Transgrid Reference Number: 2025-283

NSW Planning Portal DA: SSD-69783064

Proposal: Wagga Wagga Lithium-Ion Battery Recycling Facility

DETERMINATION: Additional Information Required

Figure 8.3 Catastrophic rupture explosion contours for 5/D weather

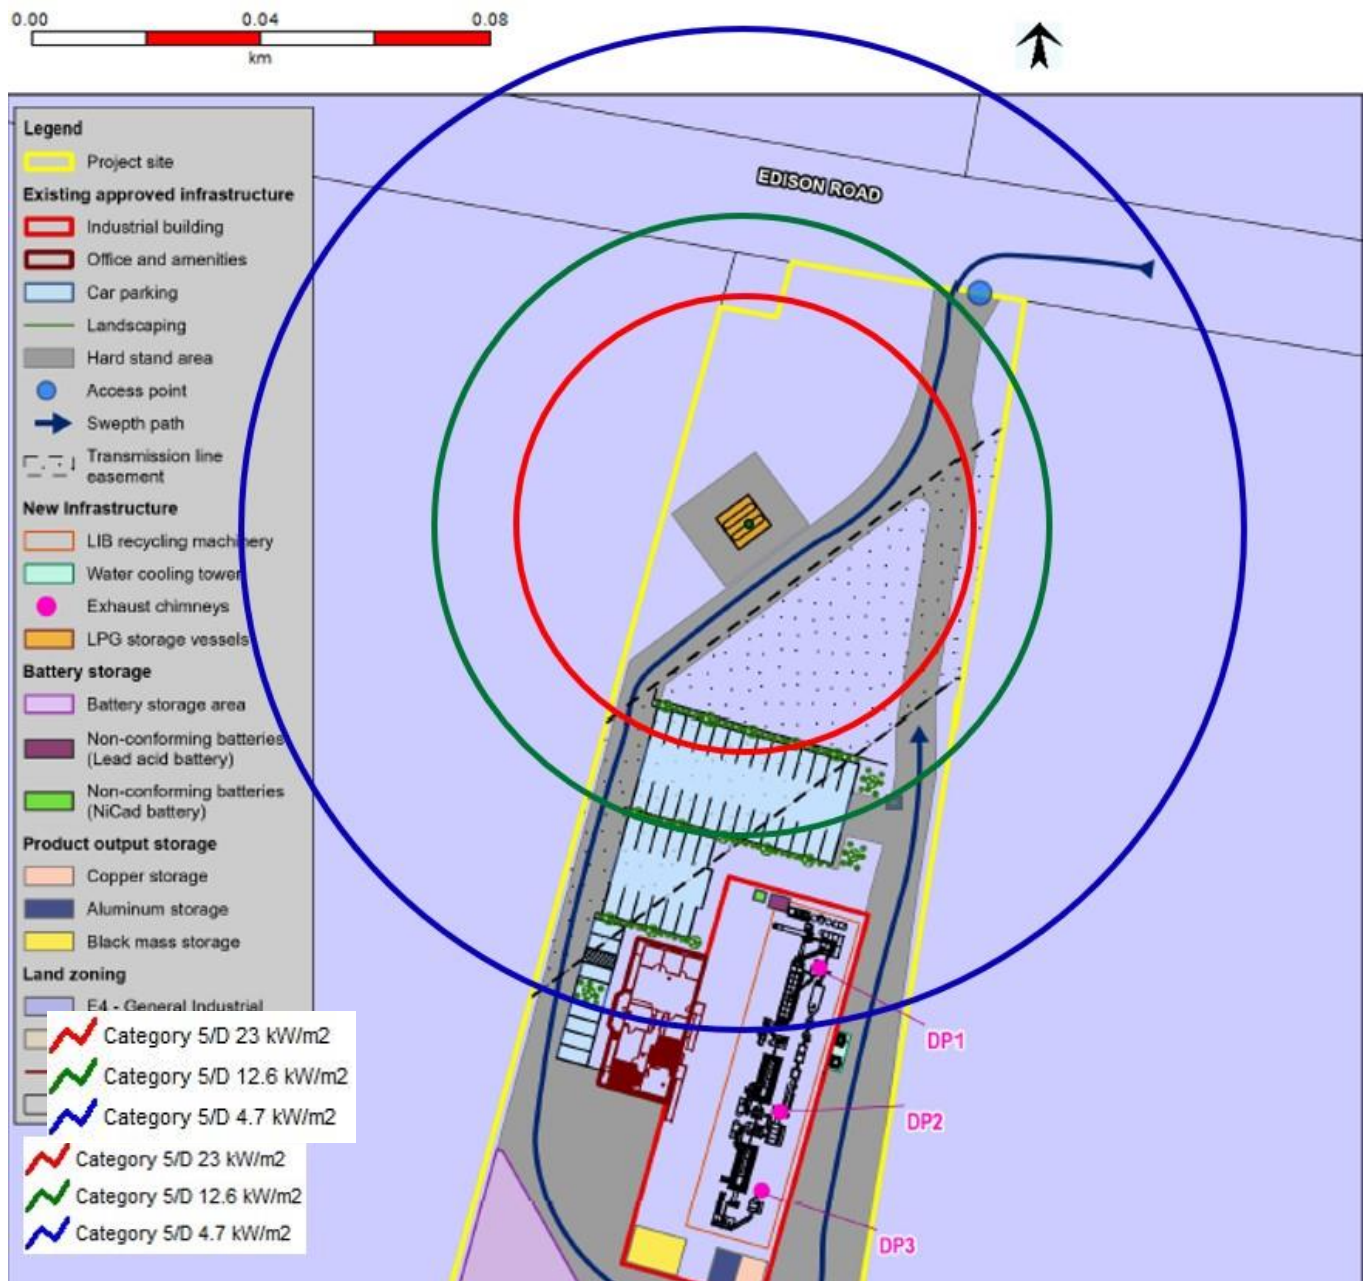
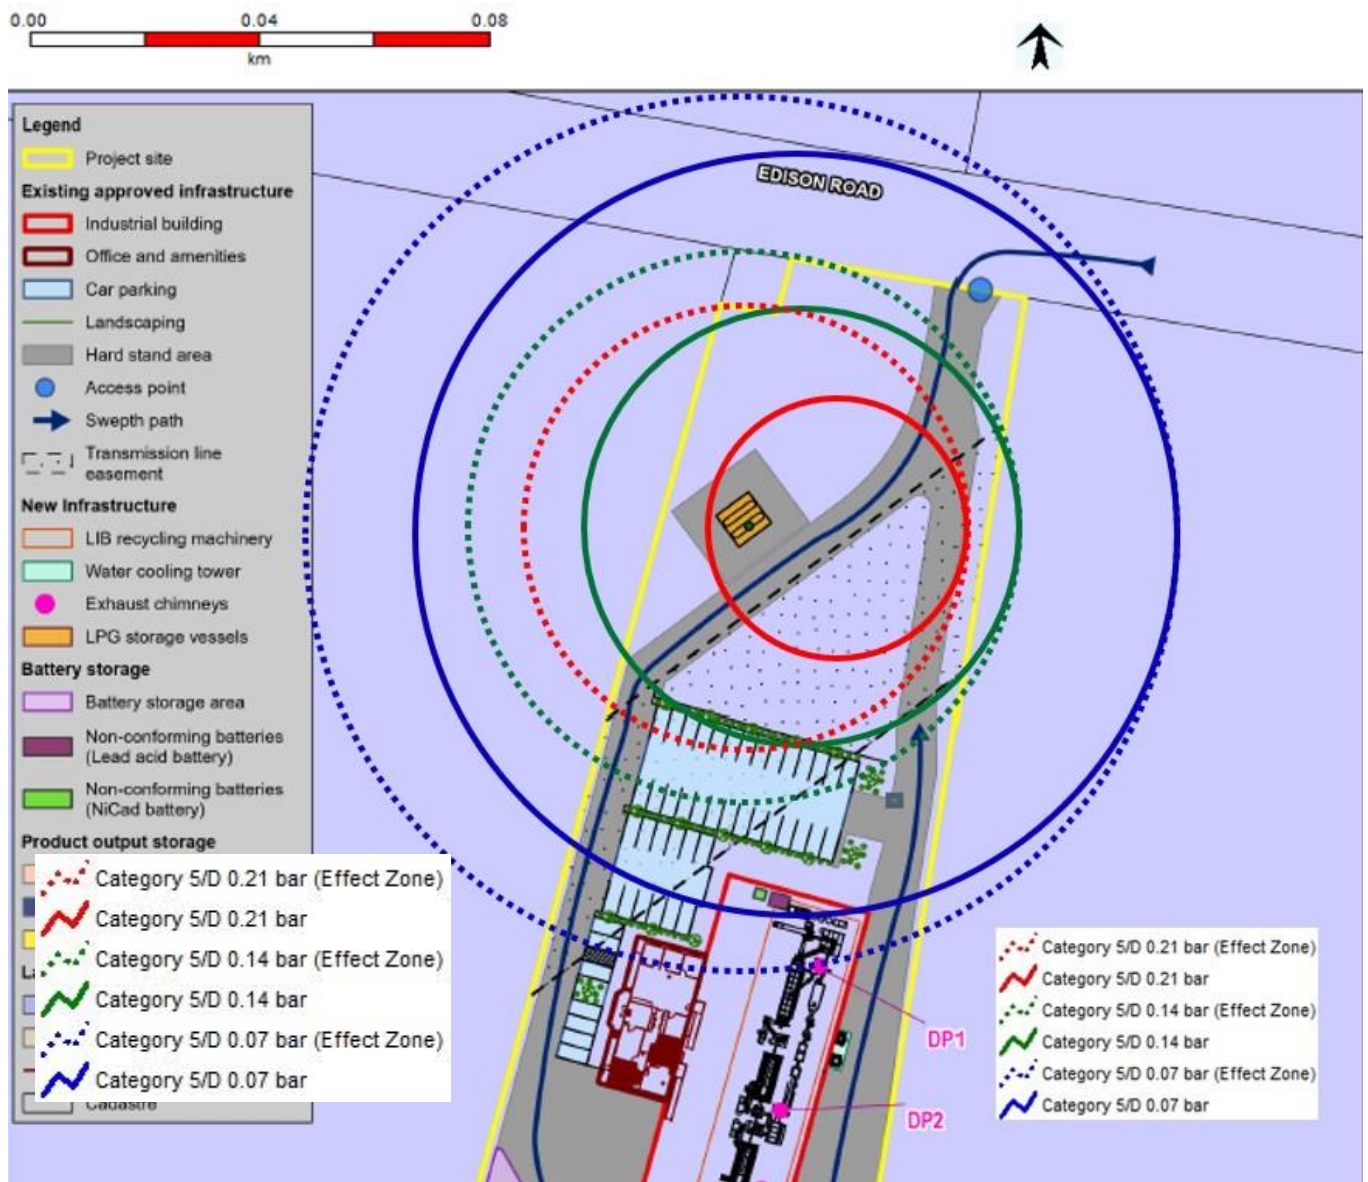
1. The developer must undertake an assessment of the potential impact of catastrophic failure (fire or explosion) of the LPG bulk storage and battery storage to Transgrid's Transmission Line 9R5 and 990 (both are 132KV). The assessment on the potential impact to the transmission line(s) must be provided to Transgrid for review and determination. Note Transgrid's Transmission Line 9R5 Structure 524 is in the proximity of this proposal.
